From: Richard Castro-Parker
Sent: 01 October 2019 11:39
To: Samantha Lee
Cc: Daniel Vick
Subject: BE/139/18/PL - Innovation Centre Beeding Close

Richard Castro-Parker
Senior Planning Officer (Contract)
Arun District Council

Figure 1: LiDAR Elevation Map (Source: OS, EA)

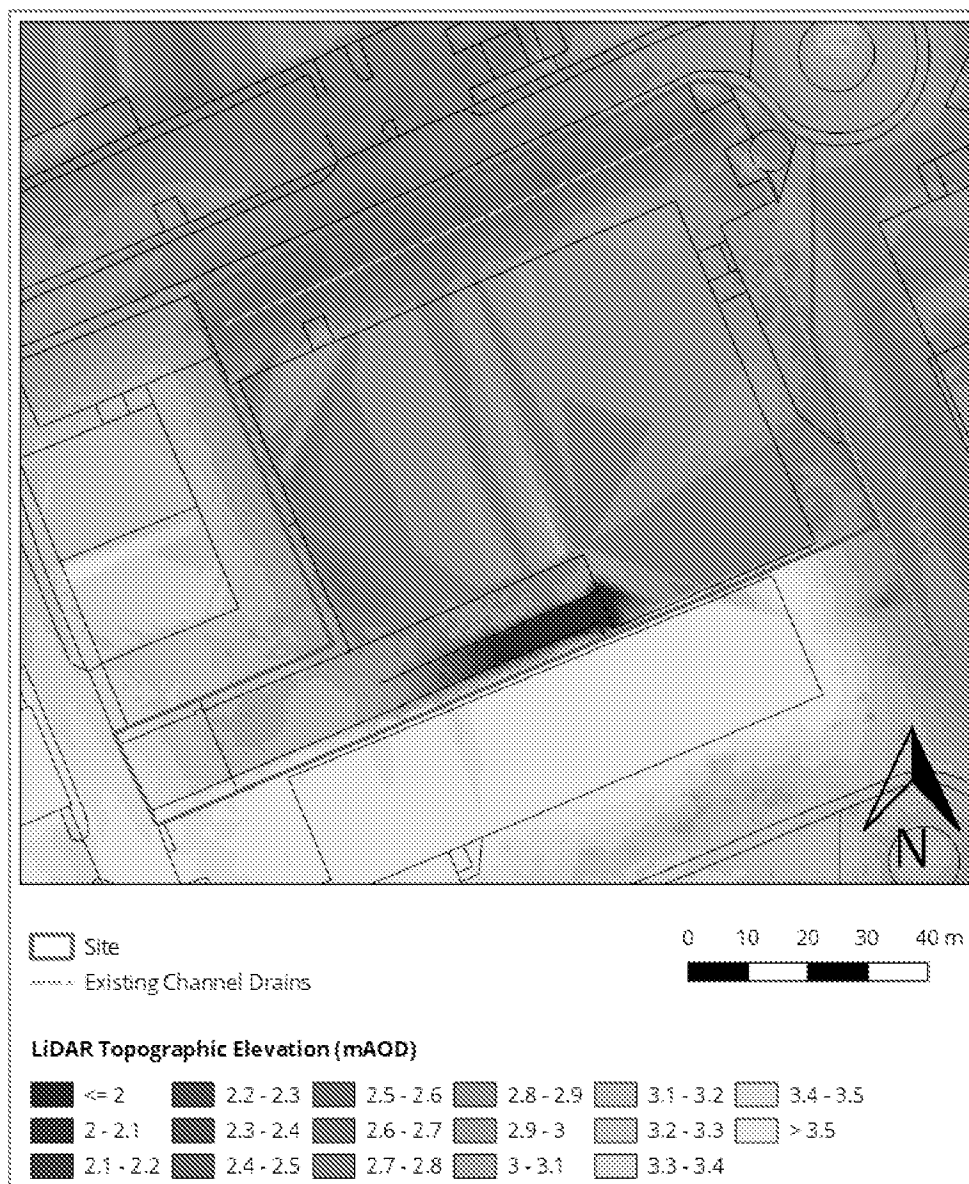
Just had a check through the correspondence on this. The surrounding levels are my outstanding requirement at this stage. If the levels demonstrate that water is being displaced off site then further information will be required.

To summarise, until the levels are supplied I cannot say definitively that I will not require further information.
